File Ref. No: BFS16/2630(12178)
TRIM Doc. No: D16/89095
Contact: Daire Fleming

**Sydney Theatre Company Internal fitout and Refurbishment Works
Hickson Road, Dawes Point (SSD 7561)**

I refer to the above development proposal's Environmental Impact Statement (EIS) which is currently on public exhibition. Fire & Rescue NSW (FRNSW) has reviewed the following specific documents that are attached to the EIS exhibition:

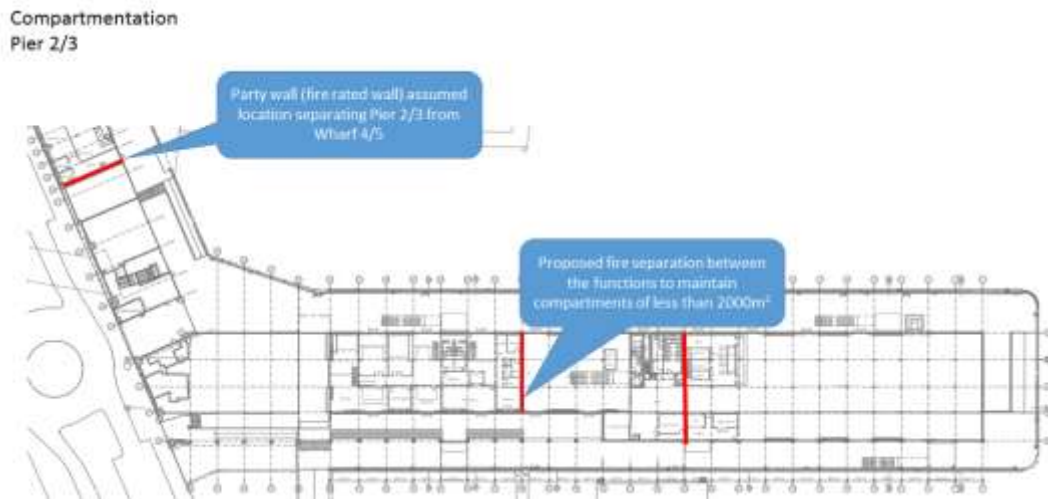
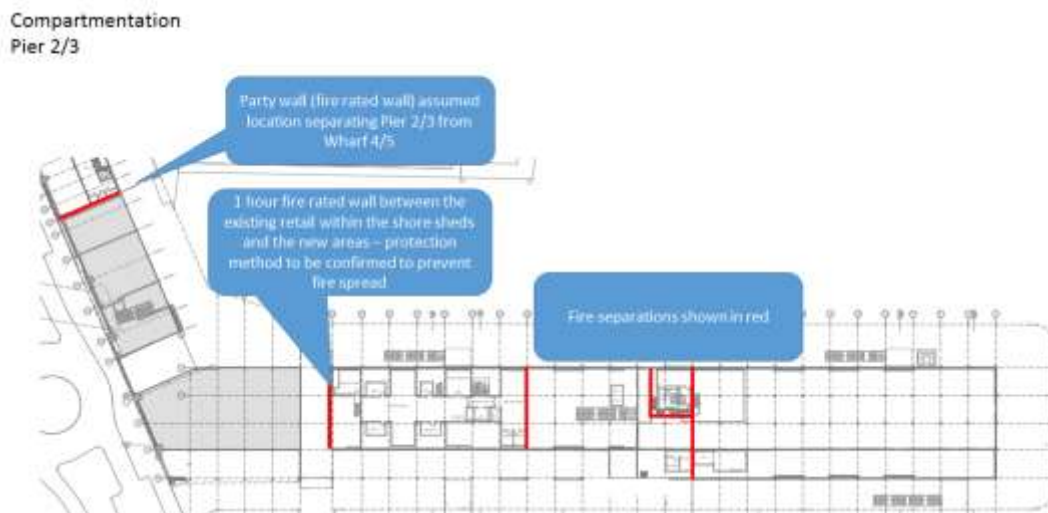
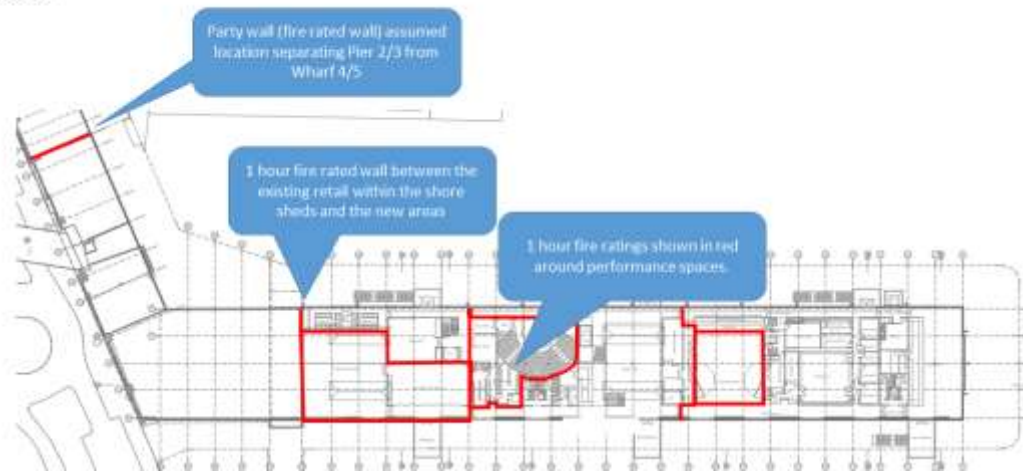
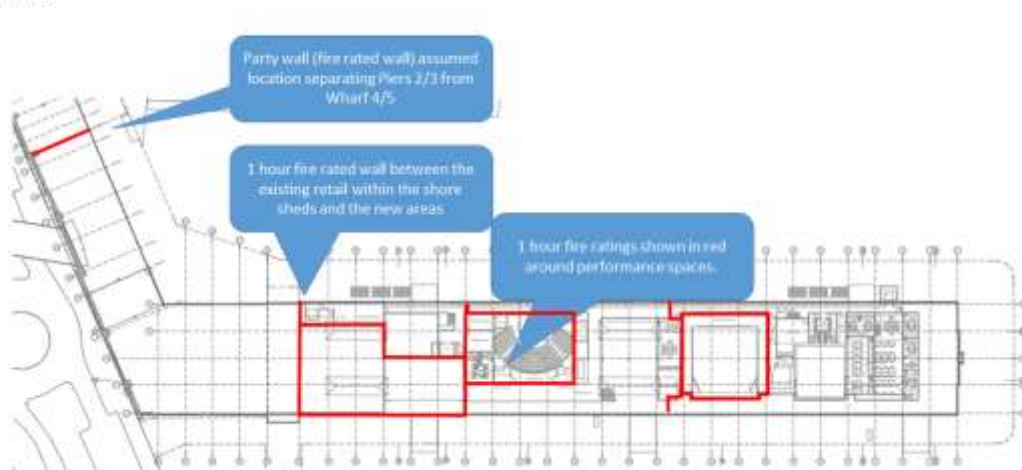
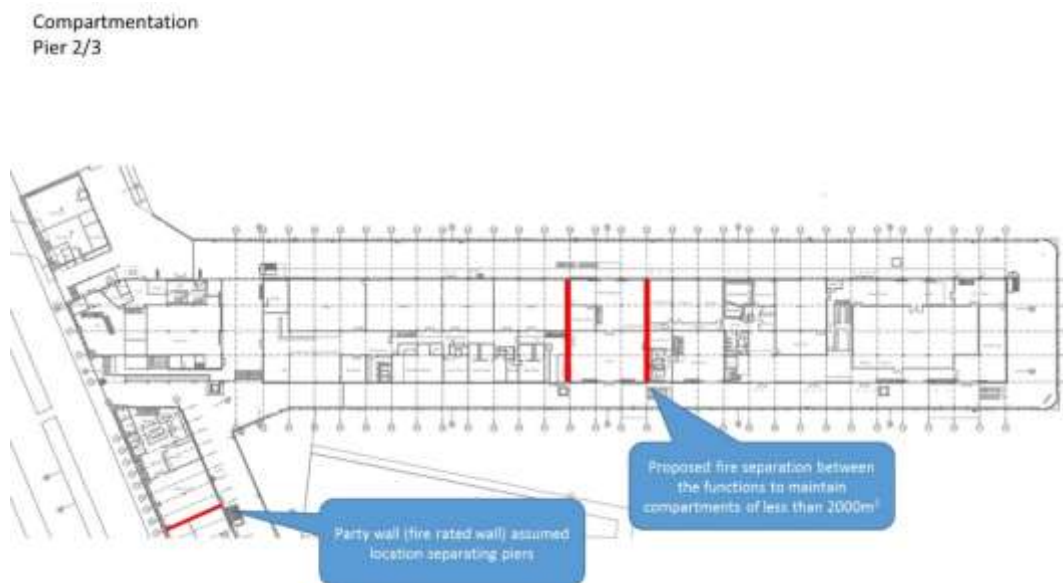
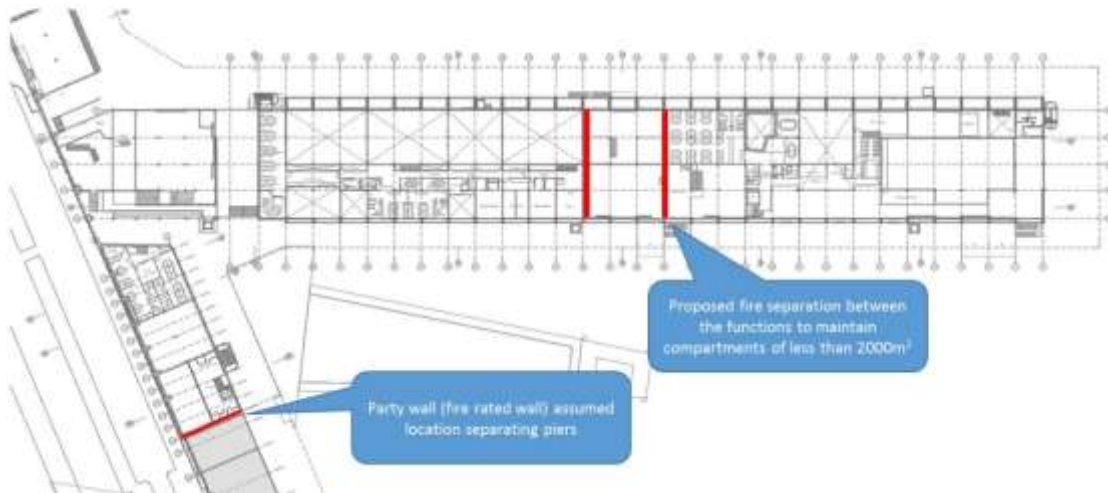
1. That the maximum compartment size is to be maintained within 2000m² floor area to limit the risk to occupants and fire fighters in the event of an emergency. FRNSW recommend that adequate compliant separation be provided between compartments to limit fire/smoke spread throughout the development. Limiting the compartment sizes will provide a sufficient period of time to afford first responders with an opportunity to protect property on arrival.
